# ARBORIST REPORT

**Addendum to report dated**

June 7, 2023

3036 67<sup>th</sup> Avenue SE  
Mercer Island, WA

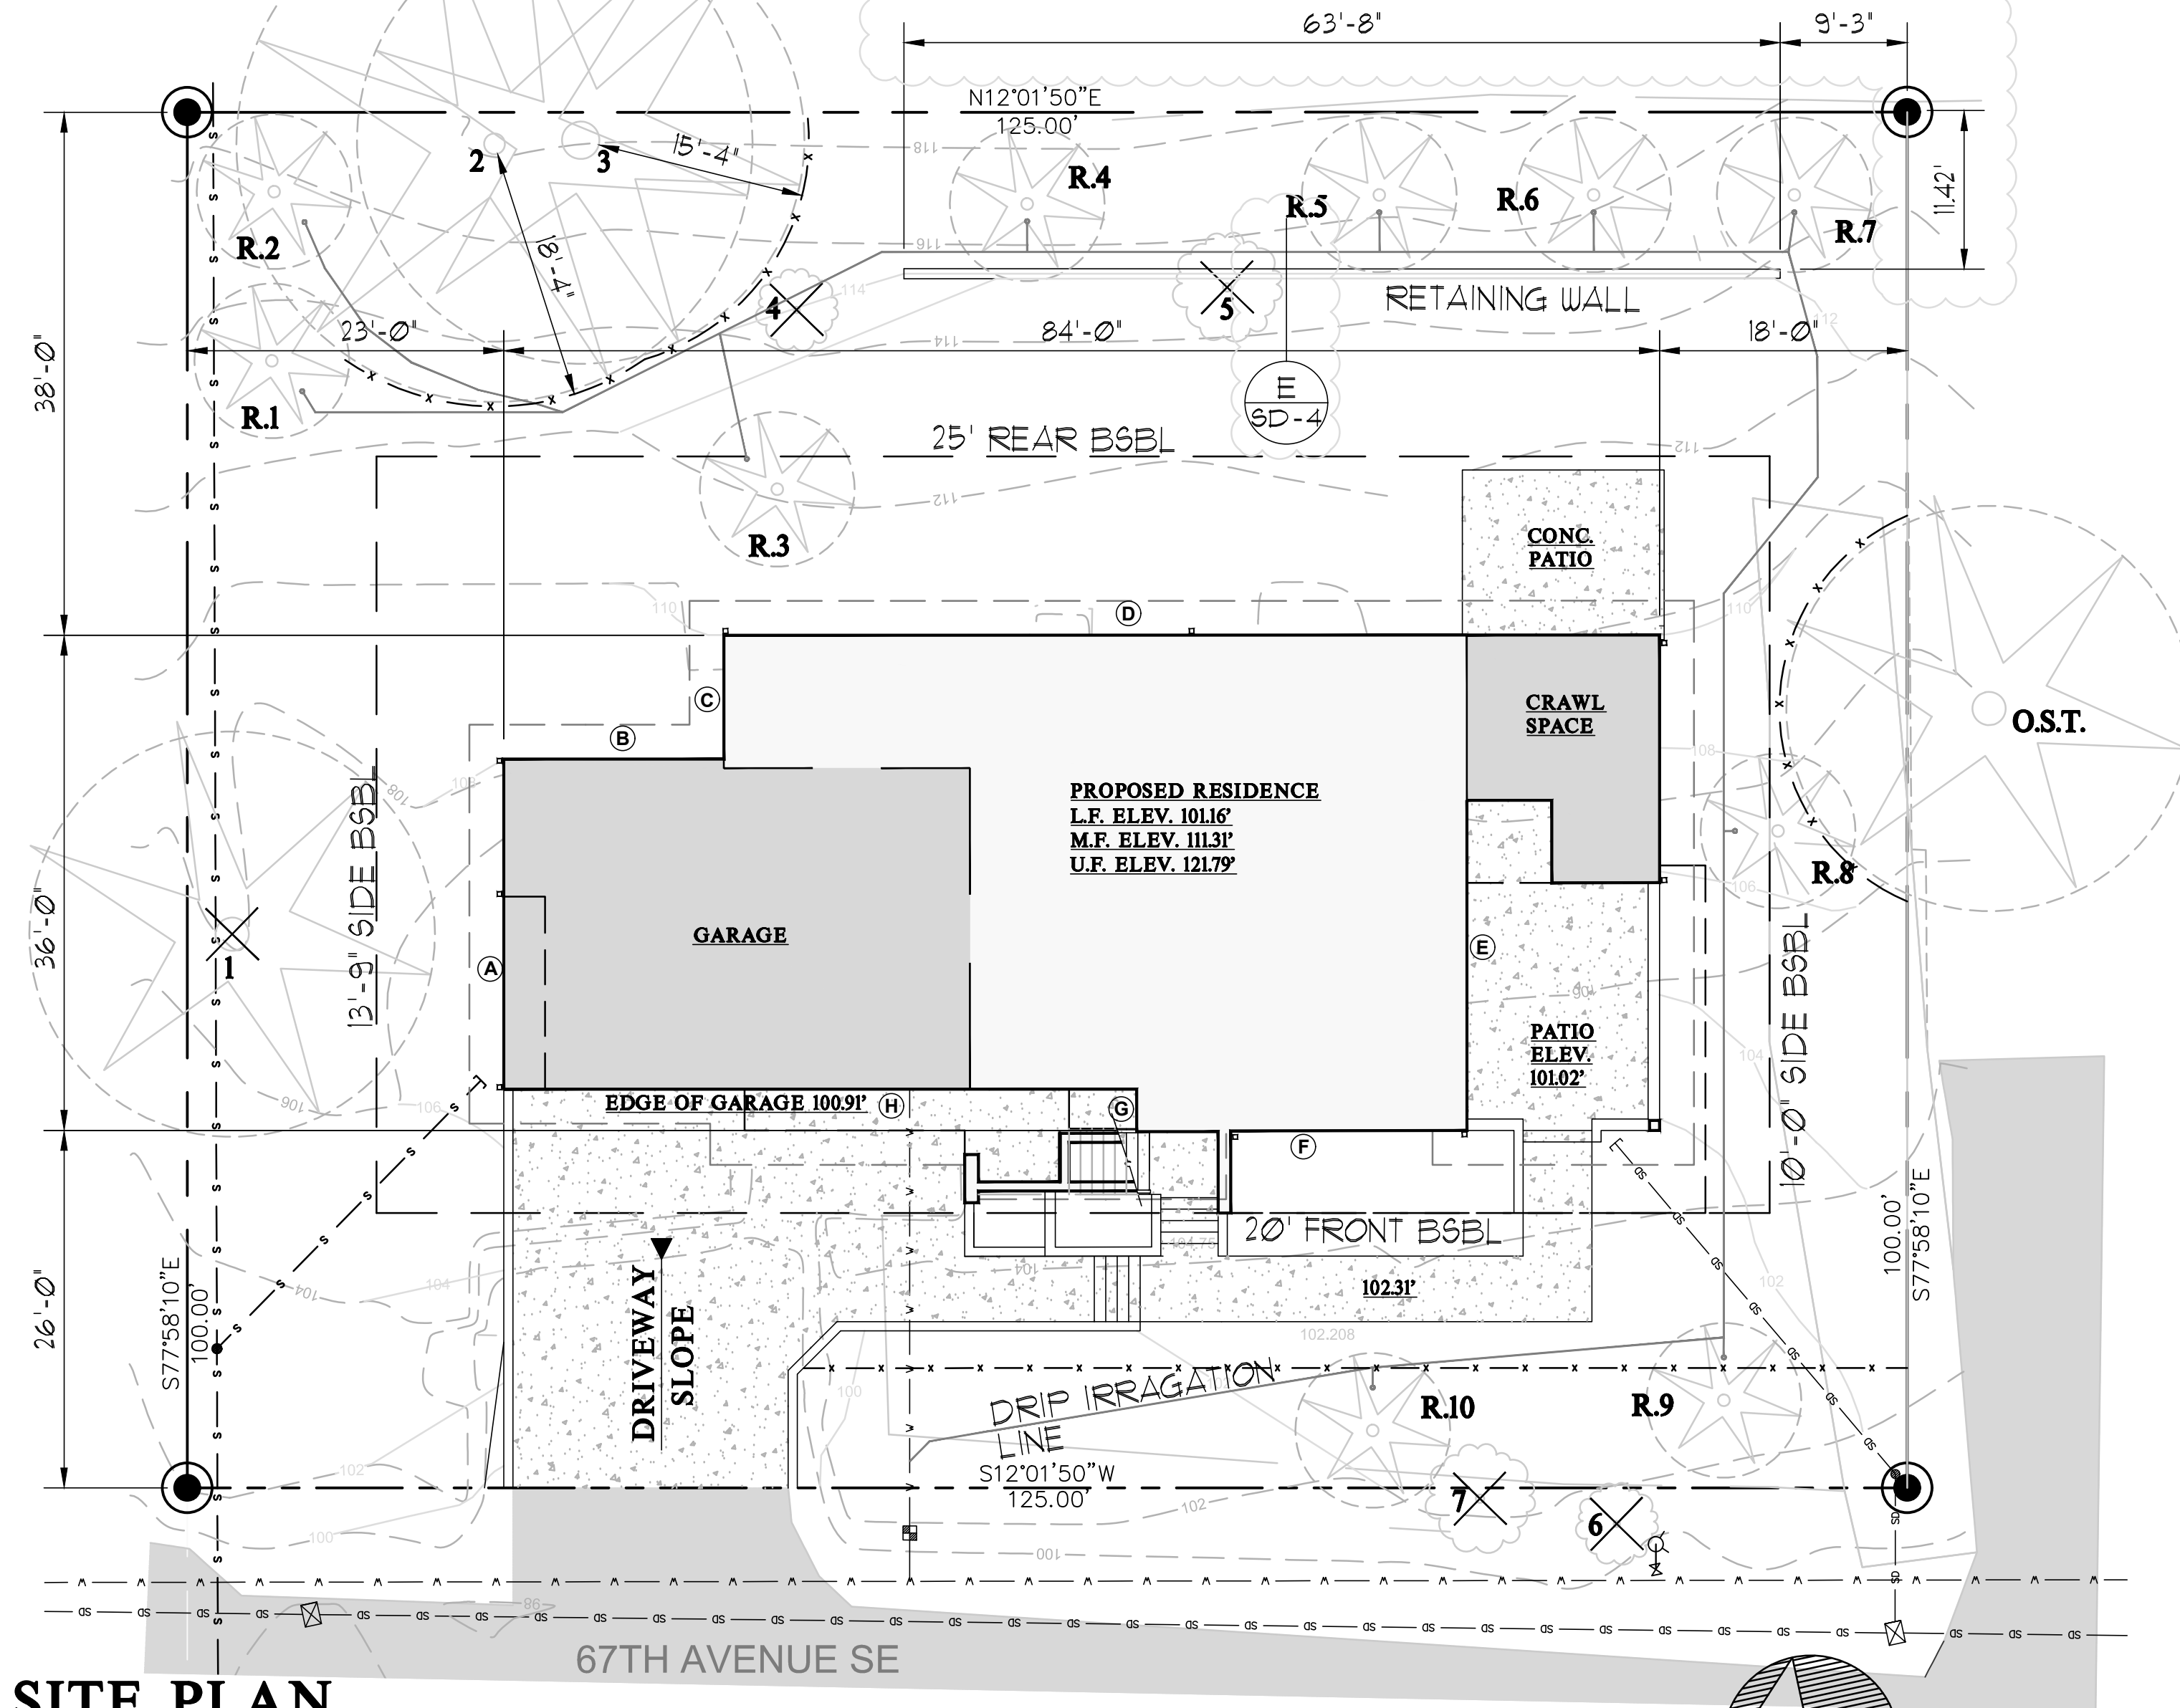
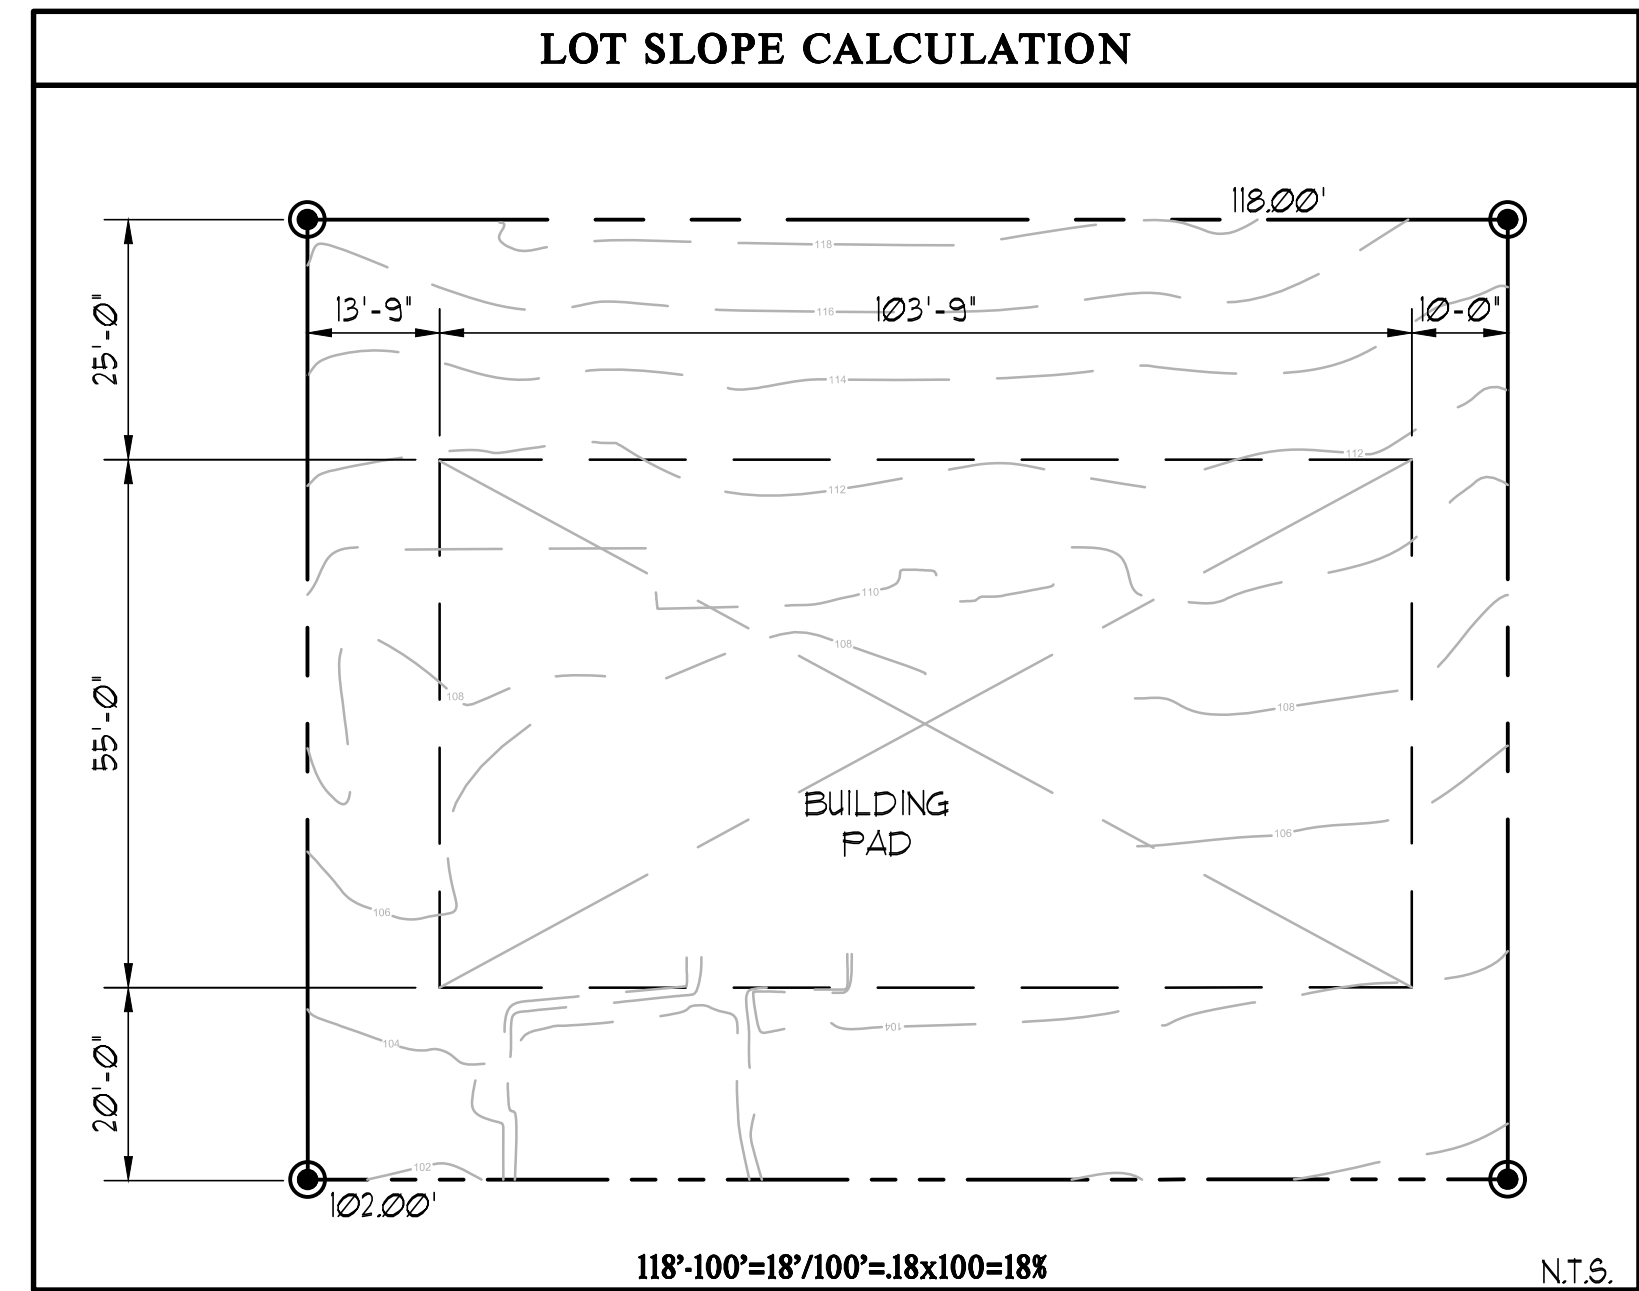
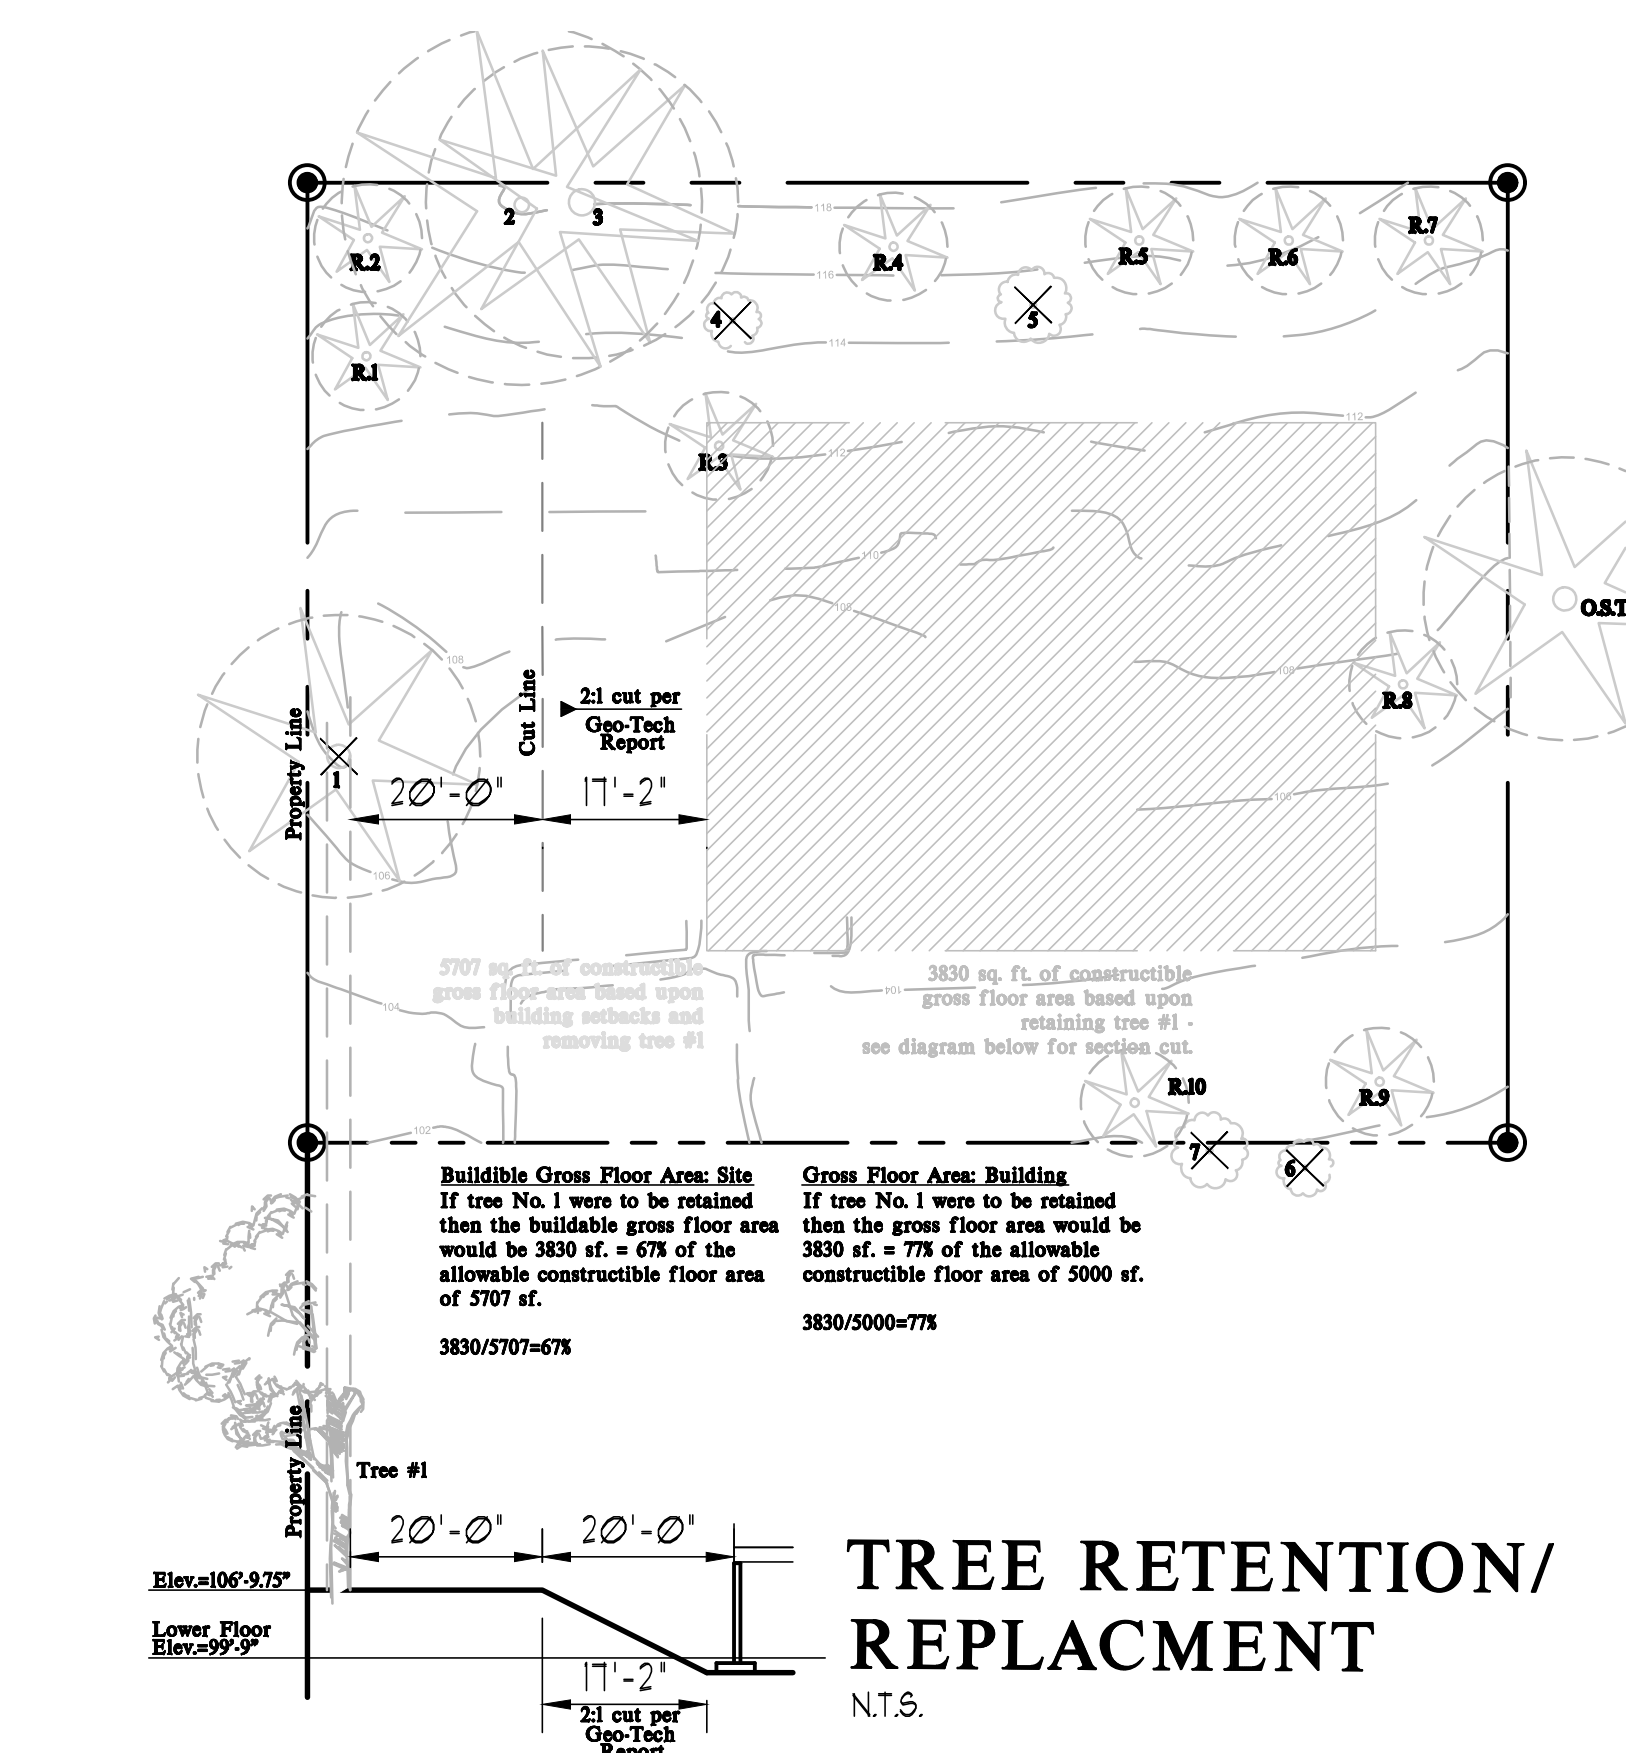
Please reference the initial arborist report for the above referenced property, said report dated October 11, 2022. I have reviewed Site Plan A1.1, revision date 6/7/2023.

Plan A1.1 accurately details the existing trees as well as the location of proposed replacement trees. Two (2) on-site trees will be retained and nine (9) replacement trees will be planted. Six of the nine replacement trees are native species.

Plan A1.1 also details the location of an off-site tree located approximately 8' south of the south property line. This tree has overhanging limbs but only because the tree is failing and leaning dramatically to the north. See initial arborist report for additional details.

The above referenced initial arborist report included Tree protection Measures, including Tree Protection Fencing and on-site arborist monitoring of excavation activity. These protection measures are included on Plan Sheet A1.1. The location of proposed tree protection fencing is detailed on this plan sheet, said location is just outside of the trees drip-line radius.
